CITY OF ALBUQUERQUE

July 17, 2012

**Re: Sunport Property Utilities Grading and Drainage Plan, Tract 22 & 23
Engineer's Stamp Dated 6-7-2012 (M-14/D034)**

SUNPORT PROPERTY UTILITIES GRADING & DRAINAGE PLAN

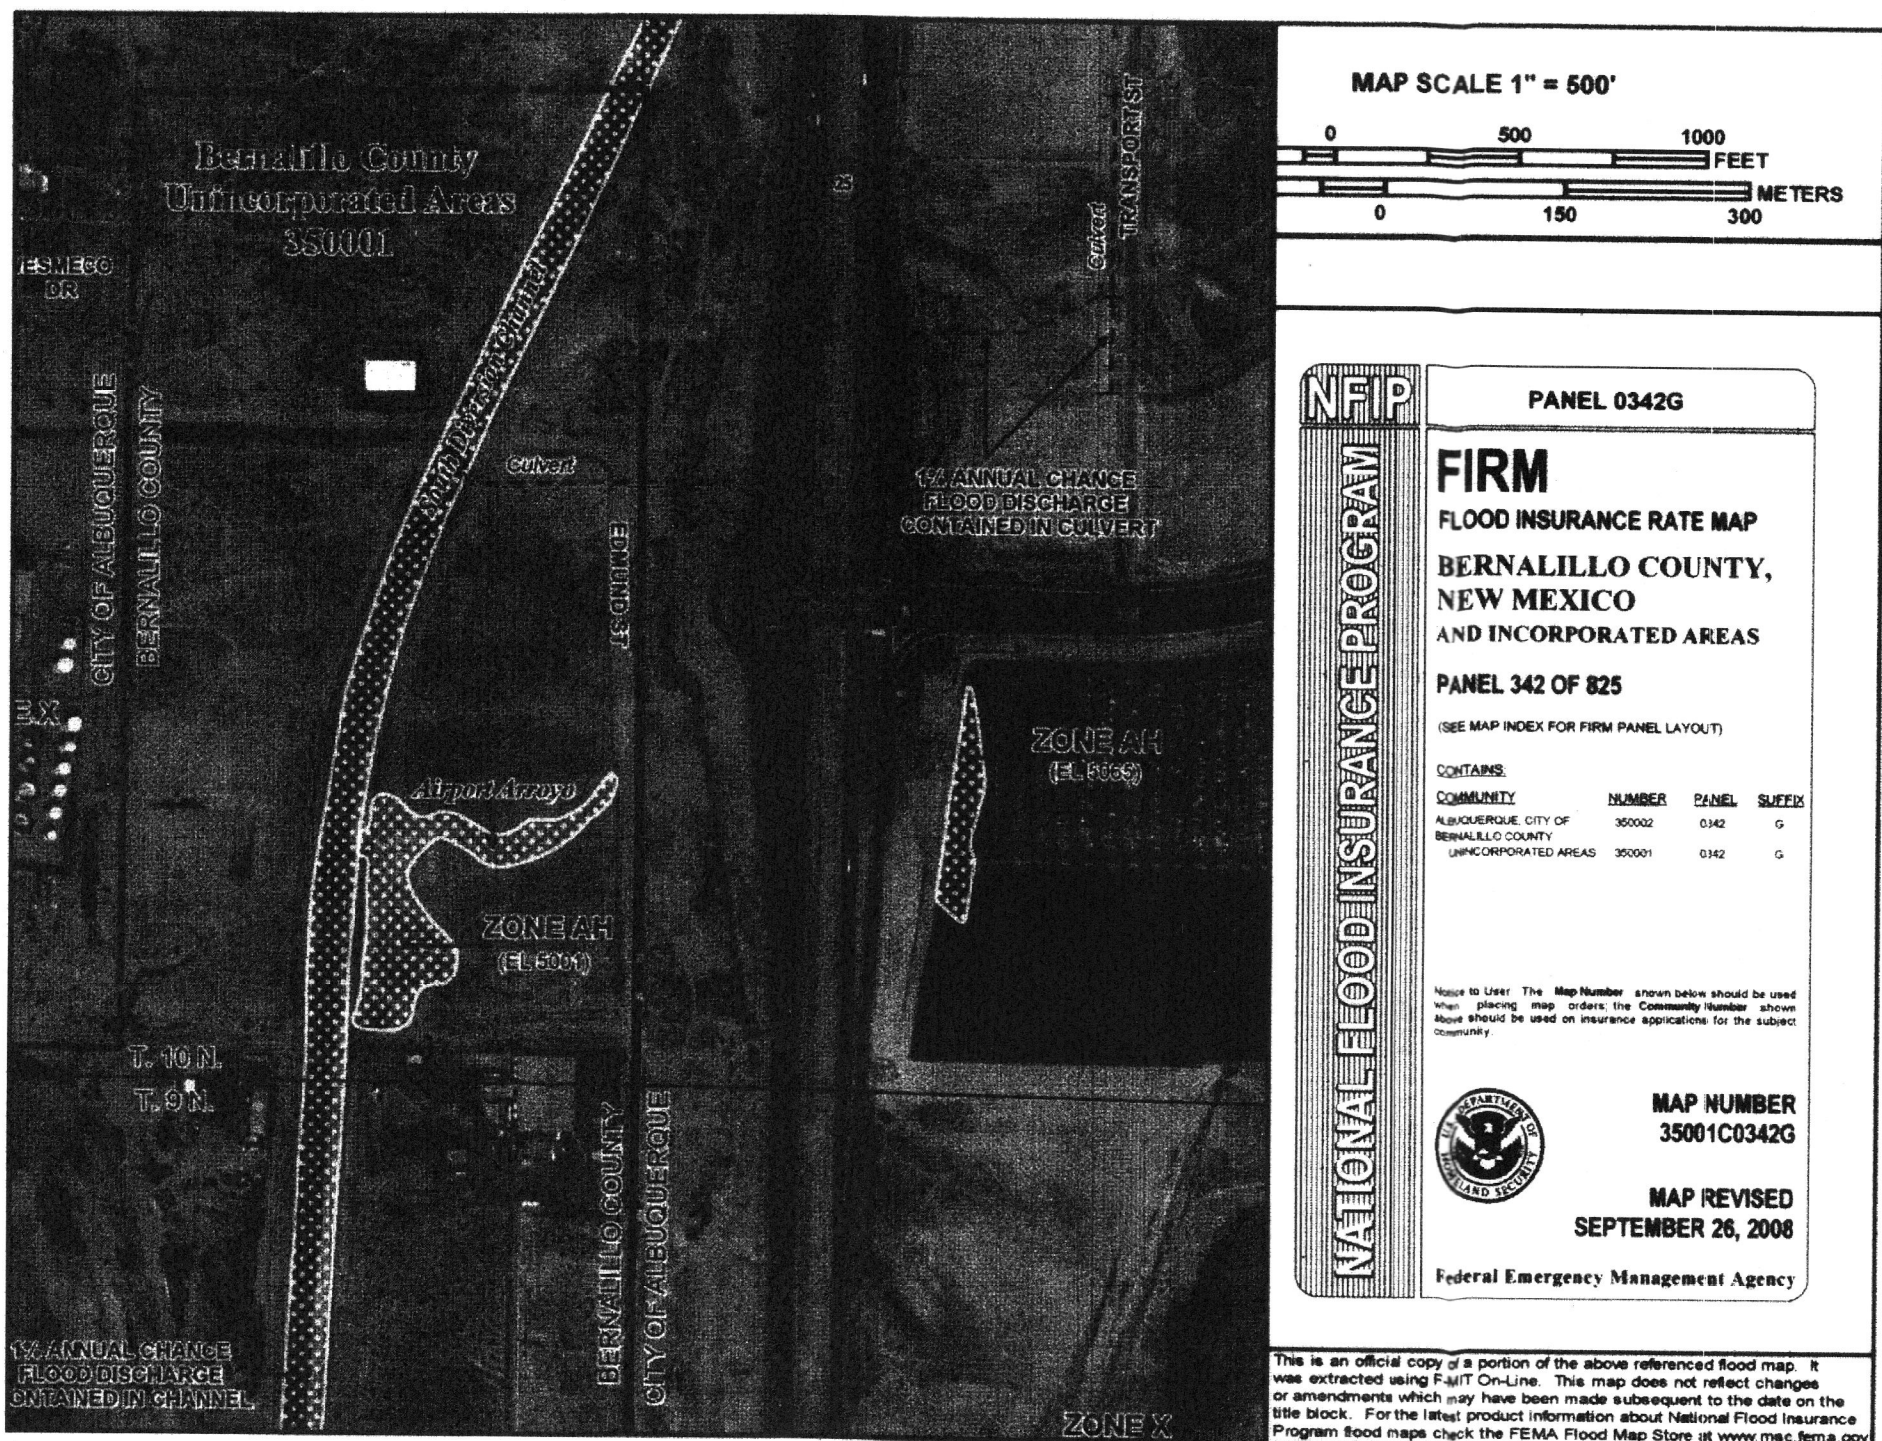
- AMAFCA approval is required for discharging into the Southern Diversion Channel.
- A floodplain permit must be obtained for grading to take place in Basins 105 and 108.
- Provide runoff calculations for each of the basins.
- It appears Basin 103 flows directly into 104 through a 36-inch CMP underneath Edmund Street and not around the basin to the north as stated in the plan.
- A street capacity analysis will be needed for Edmund Street to ensure flows are contained from Basins 106C and 106D.
- How are flows directed north along the western property edge to the Airport Arroyo Pond?
- Several A-A sections are noted on the plan, are these all supposed to be the same detail?
- Section B-B as well as many of the basin flows are not clearly visible on the plan.
- The effective floodplain date in the legend should read "9-26-2008".
